29 FLORIDA STREET  
SYLVANIA (SSD-83258708)

RESPONSE TO SUBMISSIONS

REVISION 04

26.03.26

TYPICAL APARTMENTS -
 SOCIAL

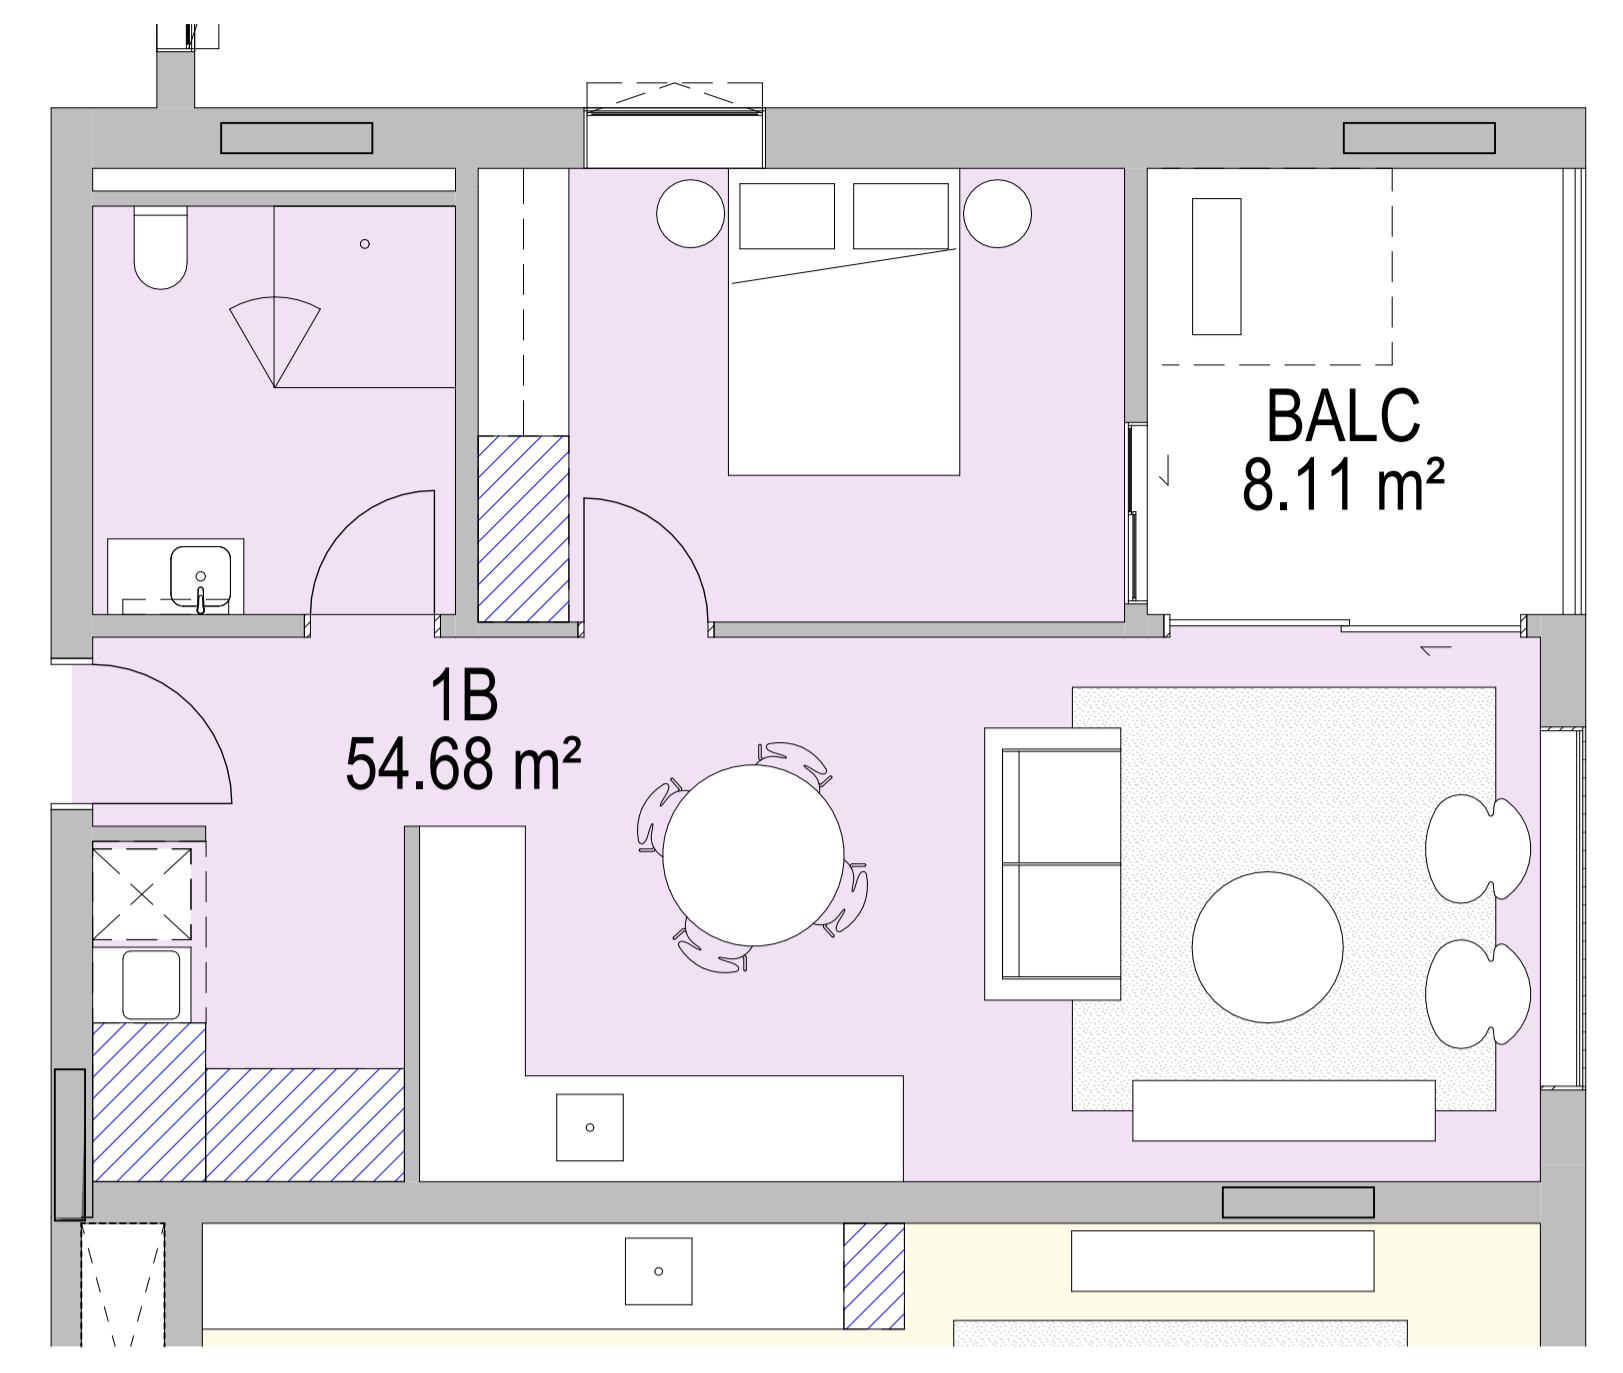
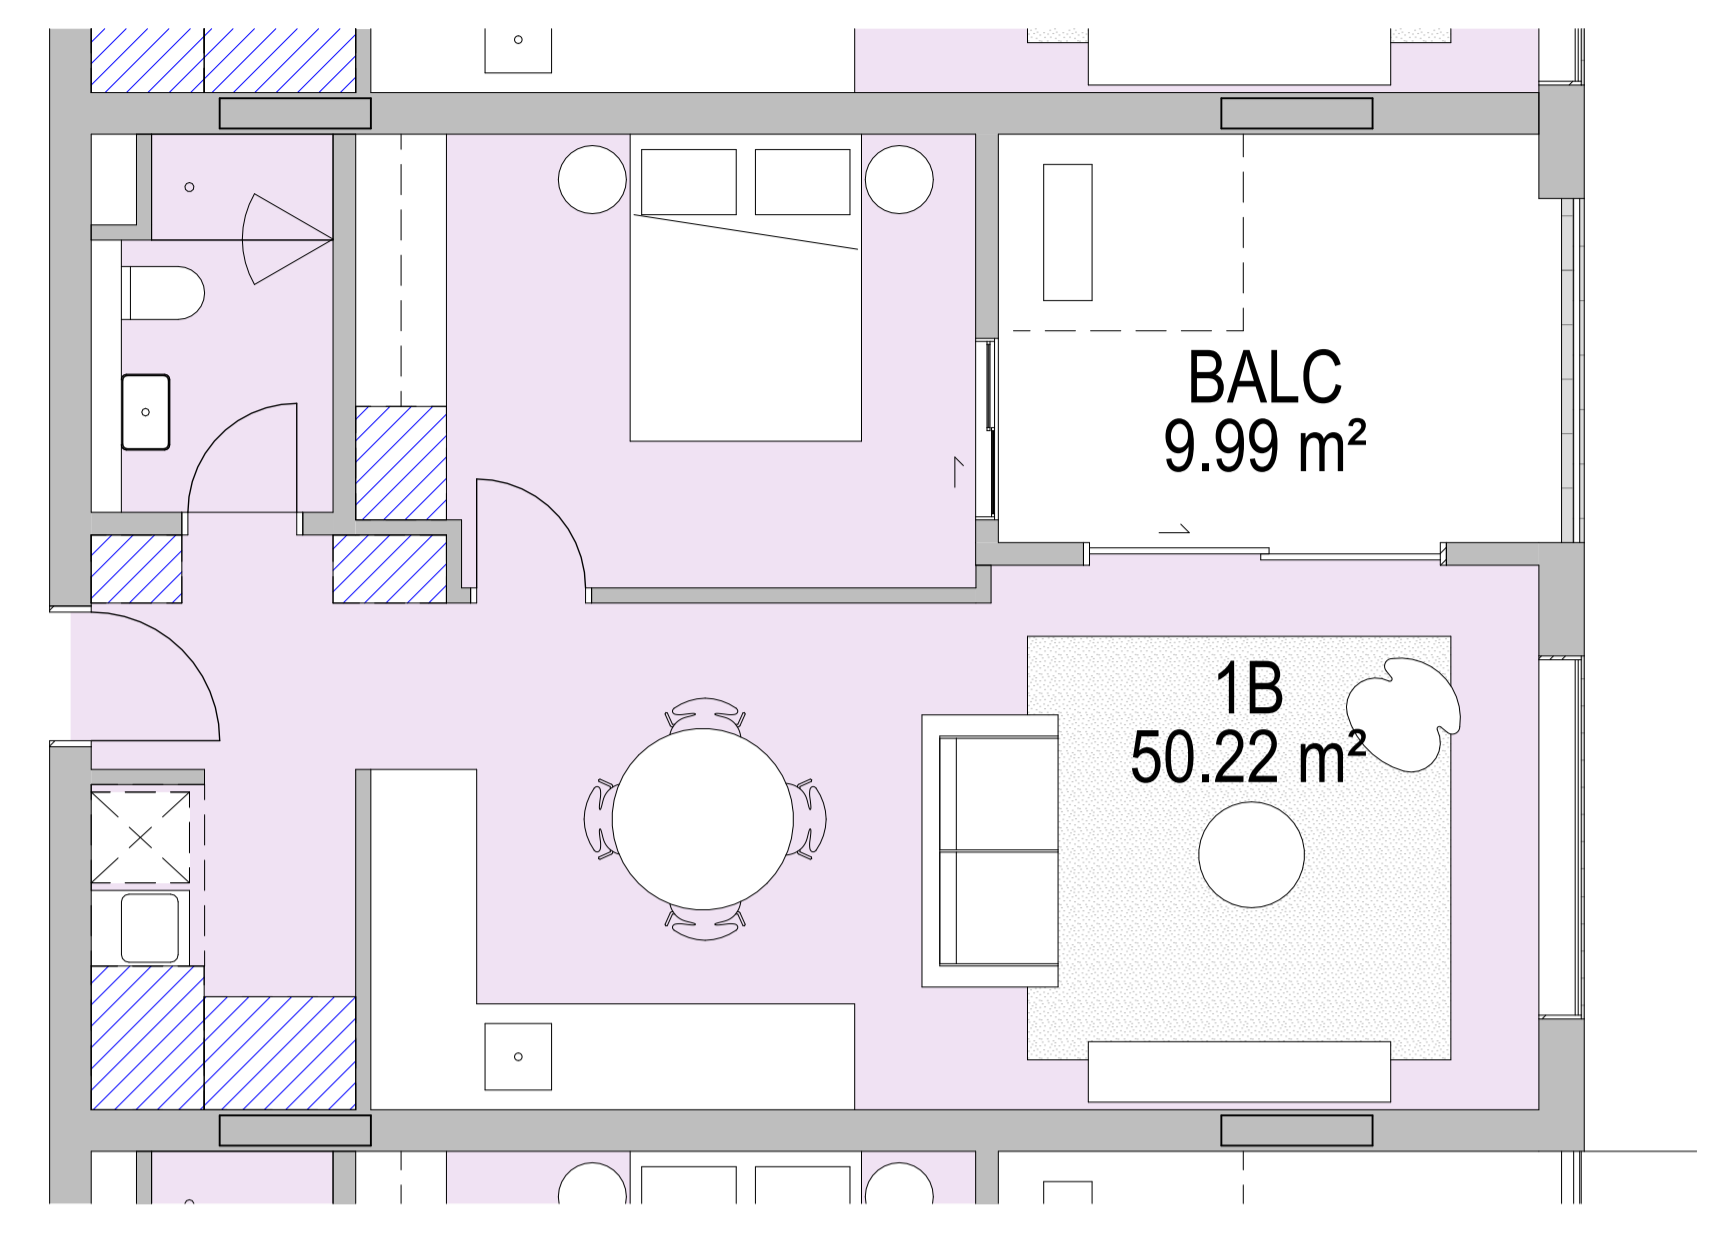
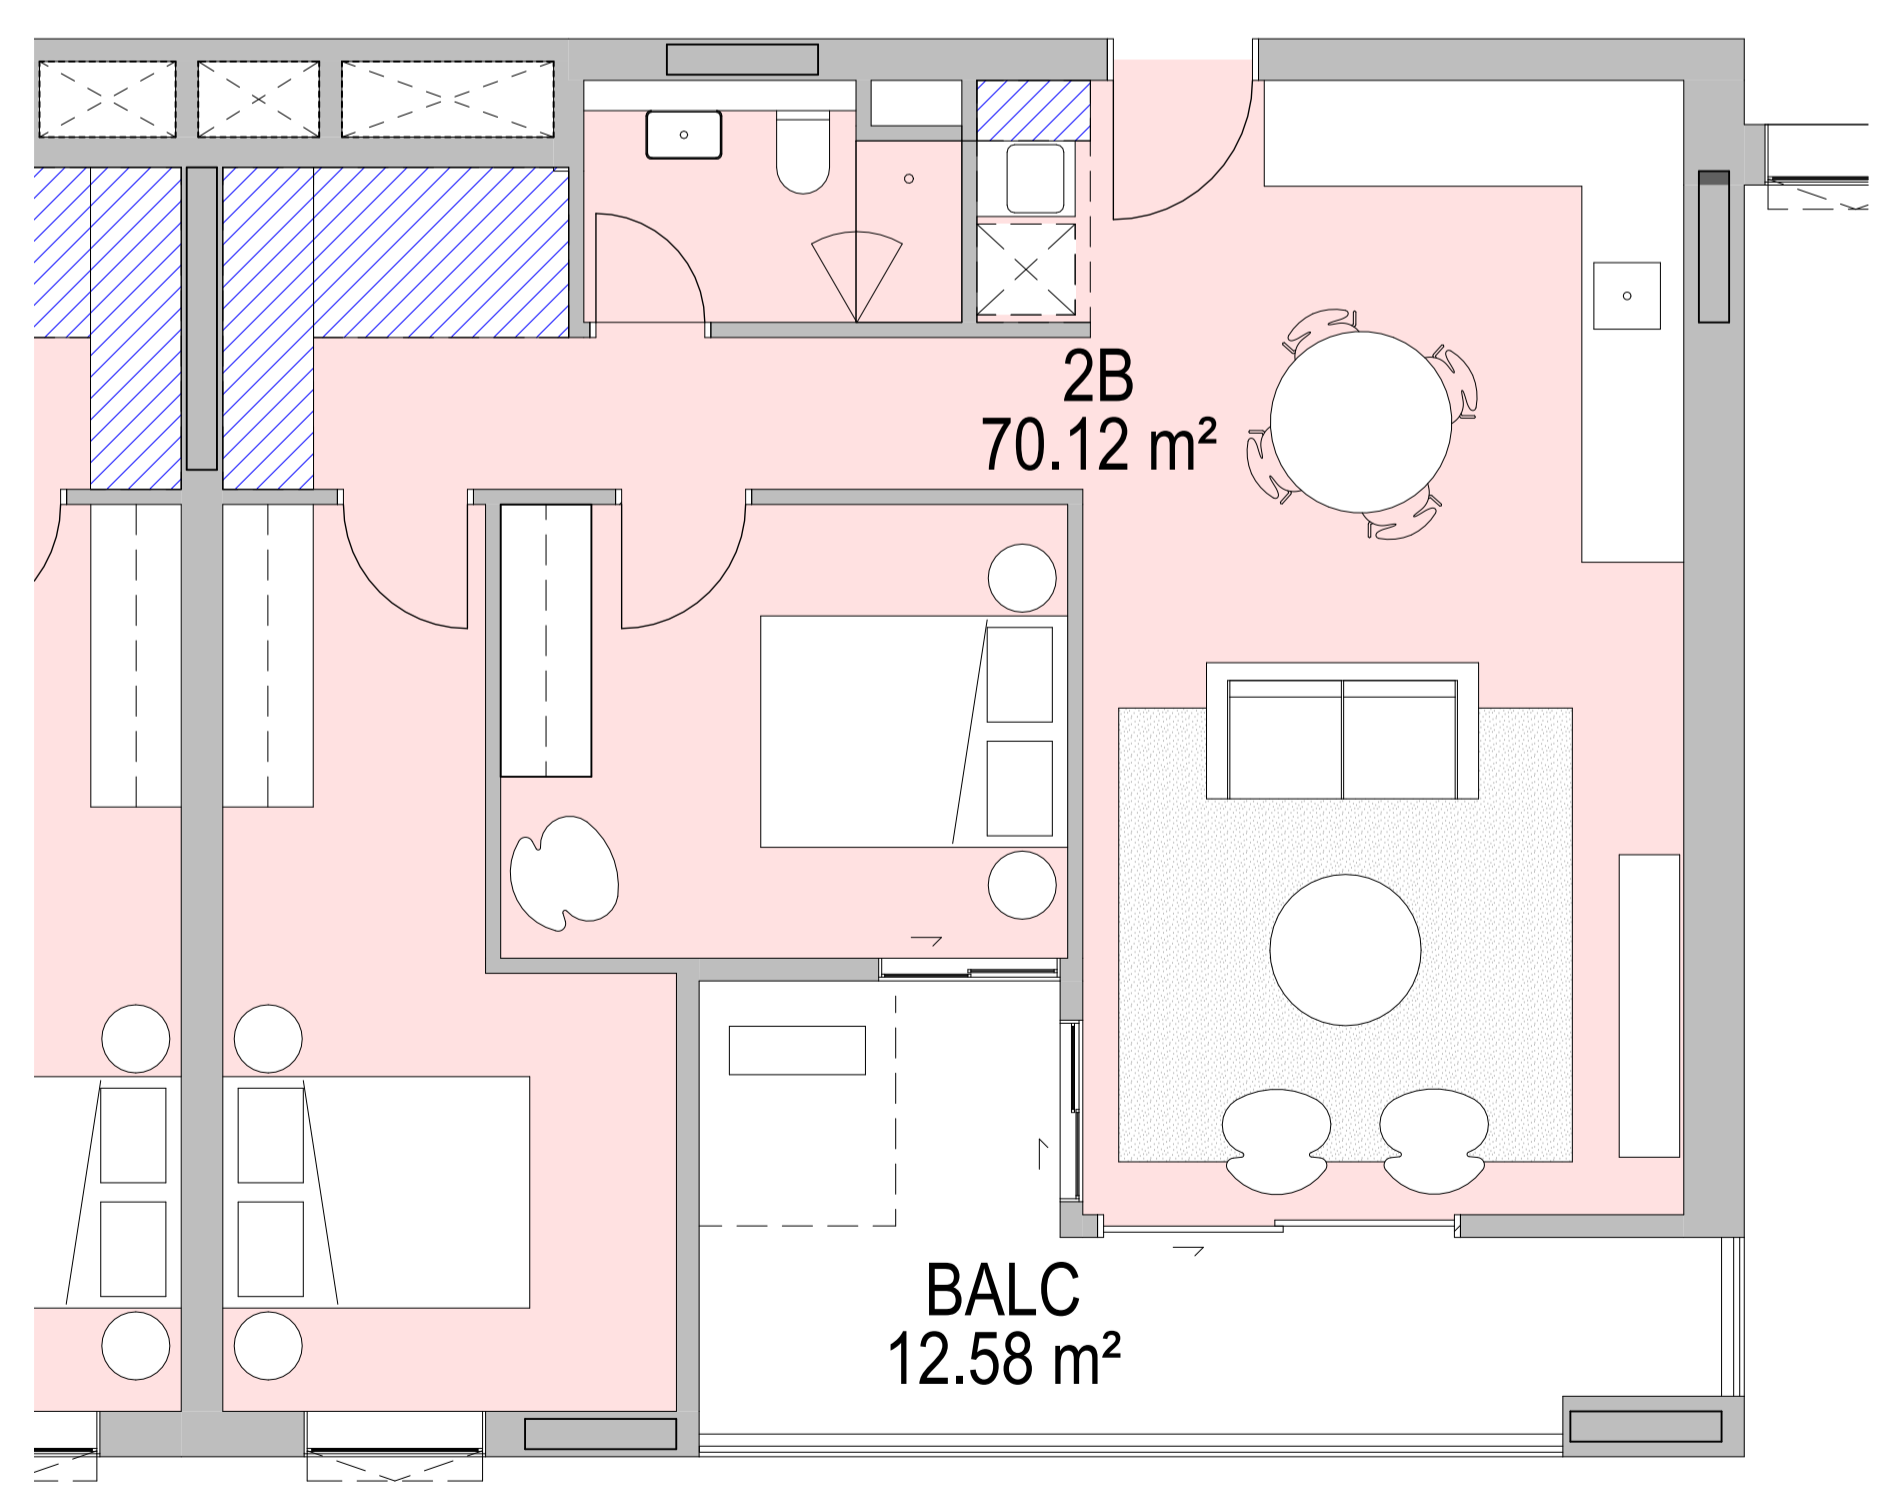
NO.	ISSUE RAISED	RESPONSE
BUILT FORM & URBAN DESIGN		
5.4	Provide annotated dimensions on plans that demonstrate all apartment sizes and layouts, and private open space areas are functional and provide a high standard of amenity having regard to the relevant design criteria of Part 4 of the ADG, specifically, Part 4D and Part 4E.	Annotated dimensions have been shown on plans for typical apartments below.
